Attachment A

1. Description of the project

The proponent is requested to provide a full updated consolidated project description that addresses the following comments:

INDICATIVE CROSS SECTIONS
PROPOSE SAND MINE
NELSON BAY ROAD
BOBS FARM

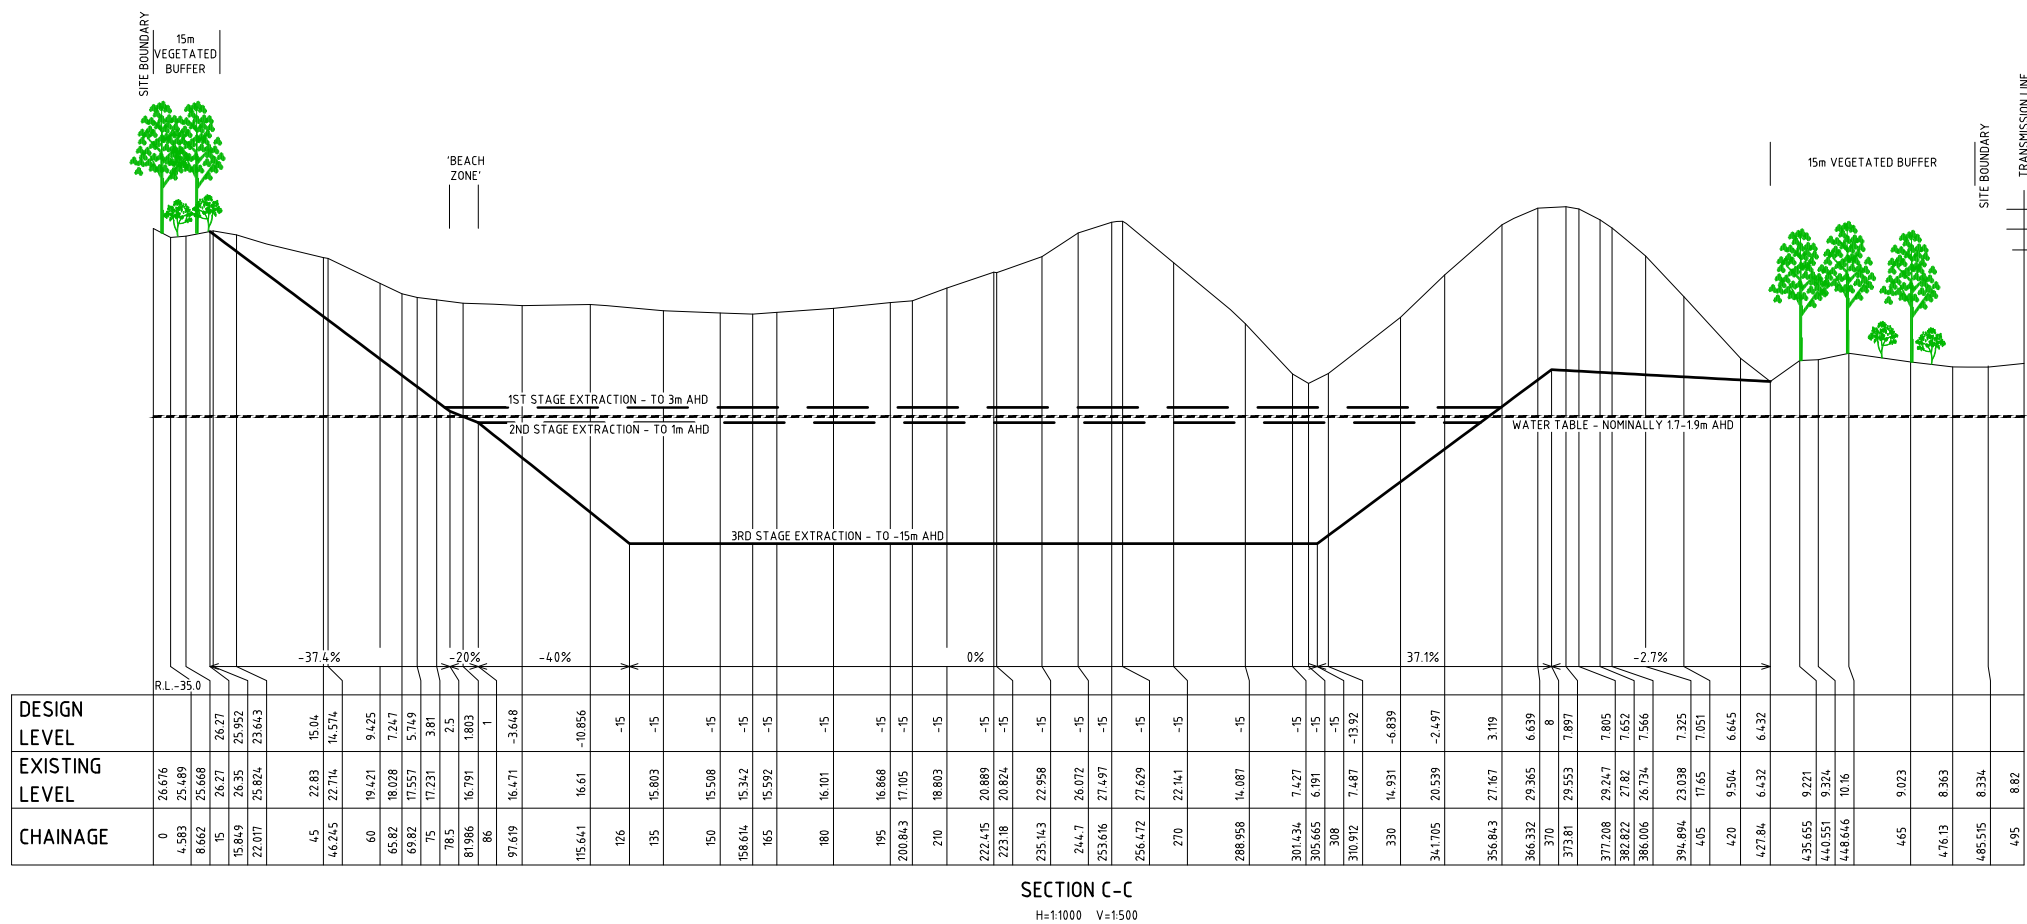
- Inconsistencies exist in the height above the groundwater table that dry mining techniques will be utilised. Section 4.5 and Figure 4.6 indicate that the proponent will use dry extraction methods down to 2 metres above the water table, while Table 4.2 indicates that the proponent will utilise dry mining techniques down to 1 metre above the groundwater table. Please clarify this discrepancy.

Figure 3: Proposed Mine Design and Configuration

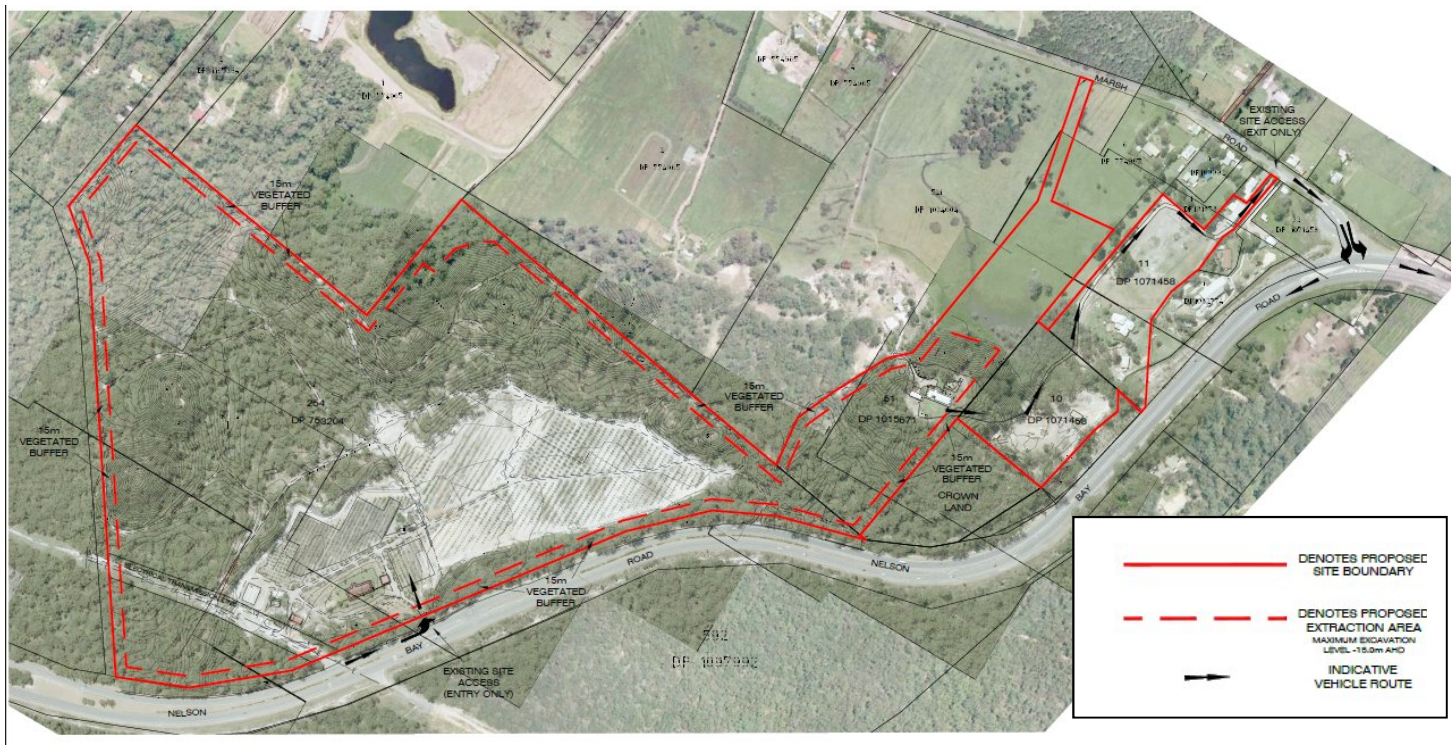
- Key mitigation measures should be described in the project description and, where relevant, shown on project layout figures. Examples include the noise bunds and walls recommended by the Updated Noise Impact Assessment and the paved haul road and enclosed screen proposed by the Air Quality Assessment.

- The updated Noise Impact Assessment recommends the construction of substantial noise bunds ranging from 6-8 metres in height around the proposed extraction area. Earthen bunds of this size will have a substantial footprint that will impact either on the extent of the proposed extraction area or the extent of the buffer zone surrounding the extraction area. The footprint of these bunds should be calculated and shown on project layout figures.
